**KIRKLEES METROPOLITAN COUNCIL
INVESTMENT & REGENERATION SERVICE**

DELEGATED DECISION TO DETERMINE PLANNING APPLICATIONS

Reference No: 2019/62/91775/W
Site Address: 81, Storths Road, Birkby, Huddersfield, HD2 2XS
Description: Erection of single storey side and rear extension
Recommending Officer: Ellie Worth

DECISION – Full Conditional Permission

81 STORTHS ROAD BIRKBY HUDDERSFIELD
GROUND FLOOR PLAN PROPOSED

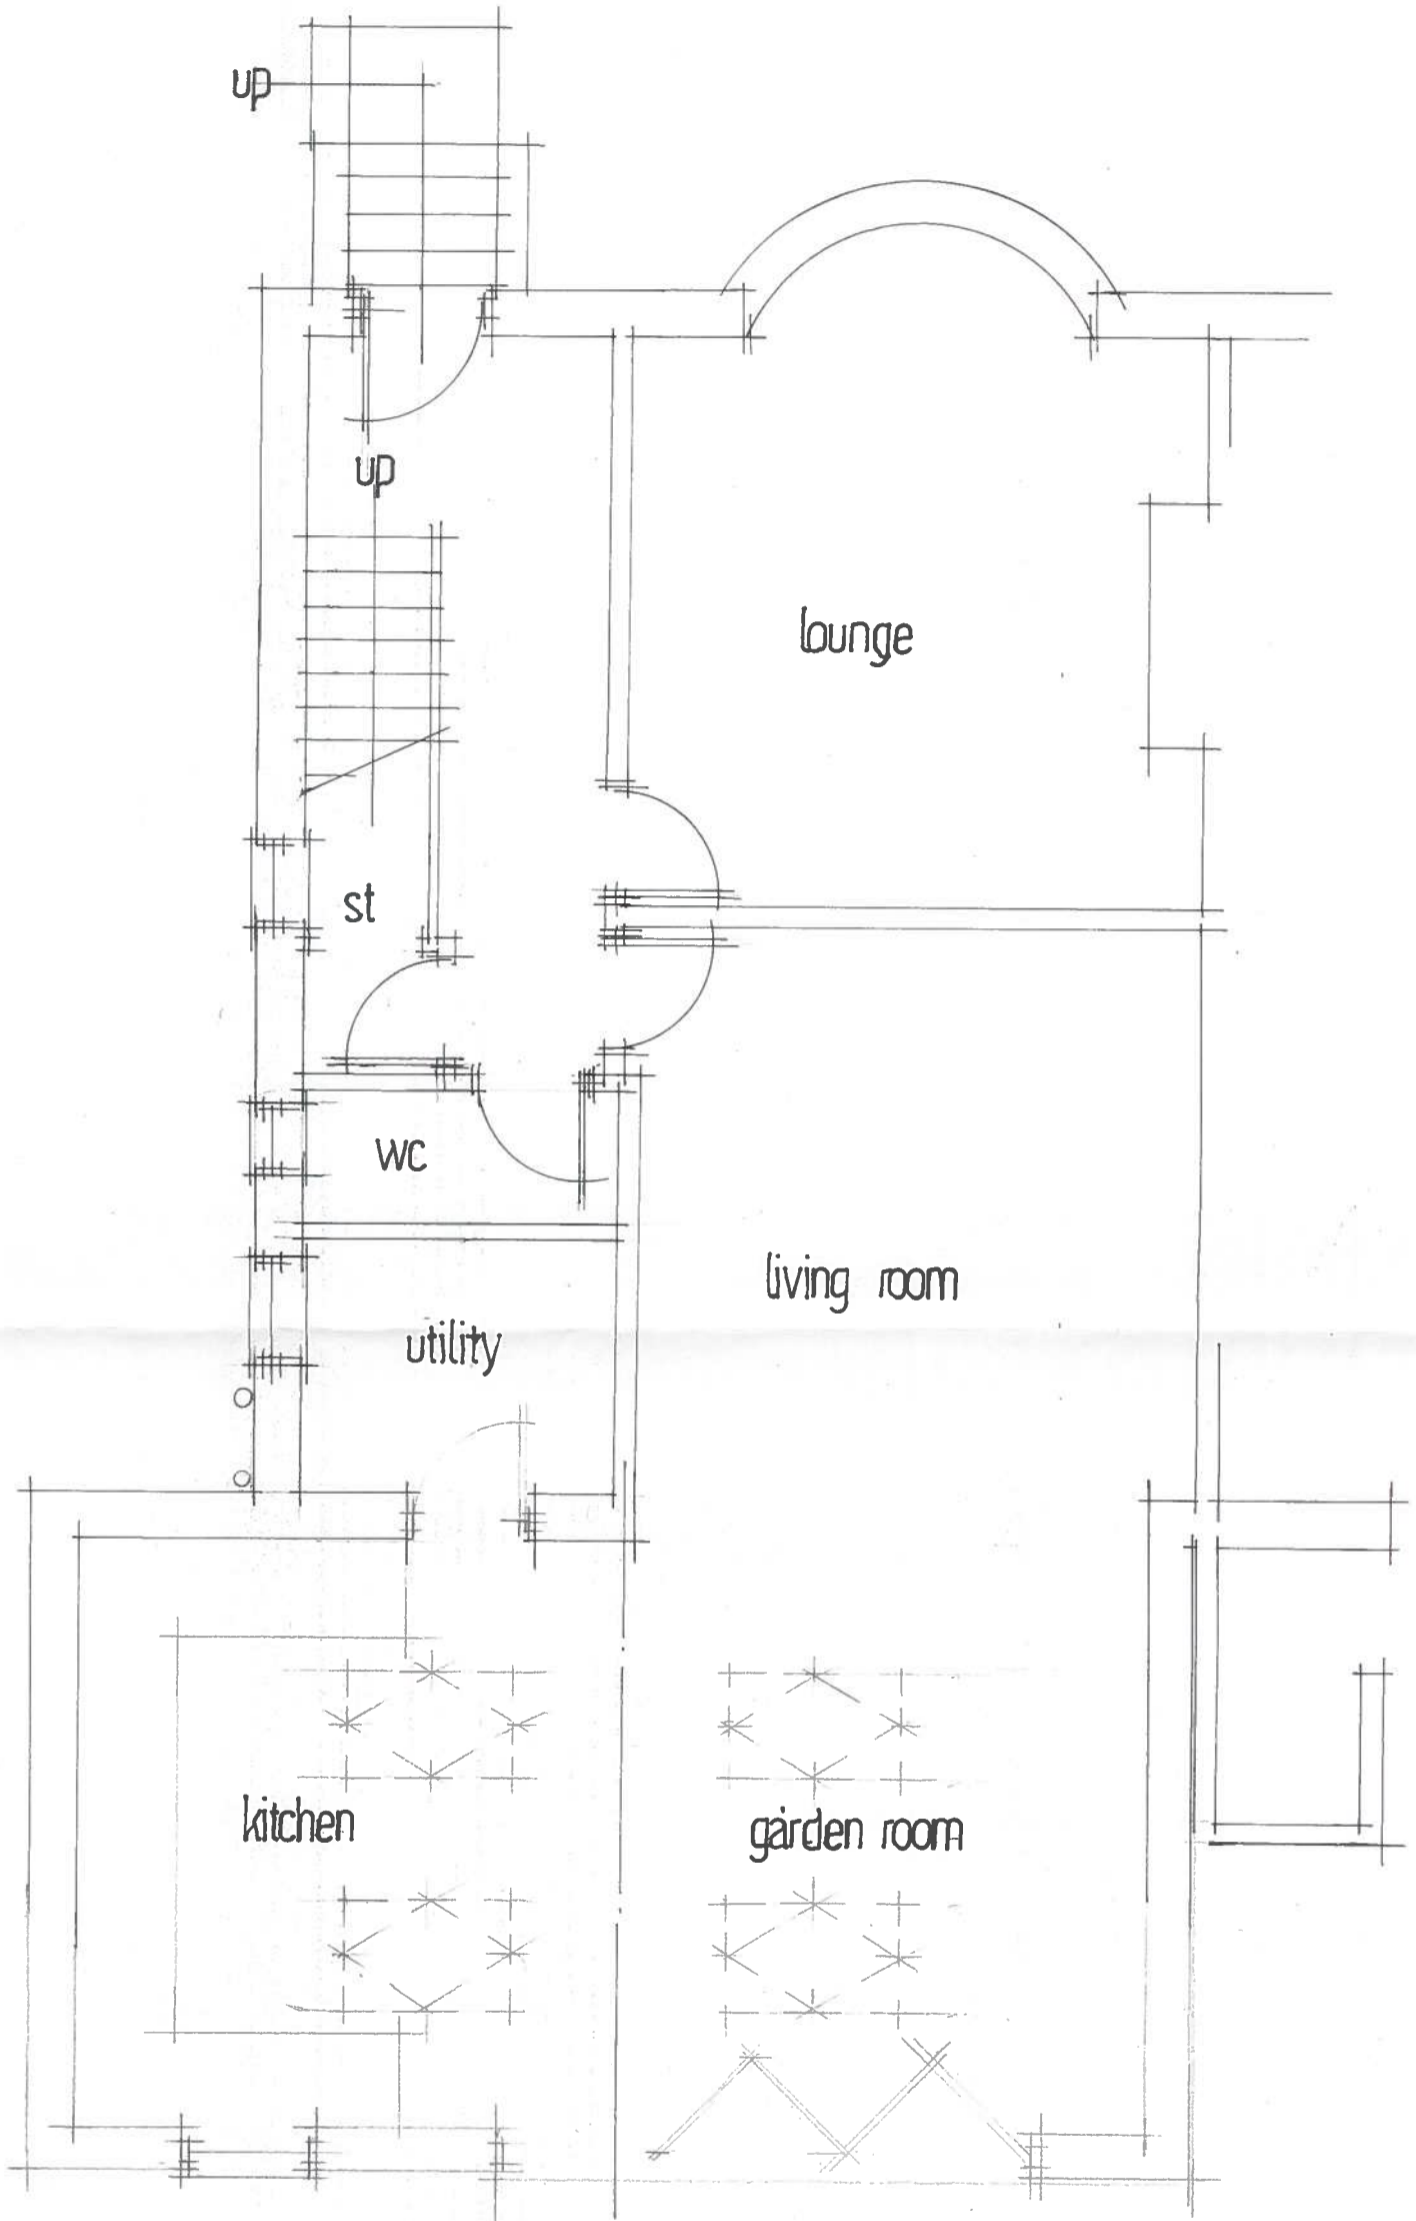
The officer entered into discussions with the agent regarding the impact in which the proposed extension would have on the neighbouring property at no.79. As such, the officer suggested that the extension is inset from the attached neighbours by 0.5m or the overall projection is reduced by 0.5m to mitigate against some of the harm. However, the agent stated that the

79 Storths Road is the neighbouring property to the south east of the application site. It has been assessed that there would be some harm to these neighbours amenity, as the extension would be located close to the shared boundary at these neighbours. As such the officer entered into discussions with the agent regarding the size of the extension, however no amendments have been submitted.

The submitted plans also show no additional openings to be inserted into the south eastern facing side elevation of the extension which will mitigate against any undue harm on overlooking. Nonetheless, to protect these neighbours and future occupiers' amenity, permitted development rights for openings within this elevation will be removed.

4. Notwithstanding the provisions of the Town and Country Planning (General Permitted Development) Order 2015 as amended (or any Order revoking or re-enacting that Order) no doors, windows or any other openings, other than those expressly permitted by this development, shall be created in the south eastern facing side elevation of the extension hereby approved.
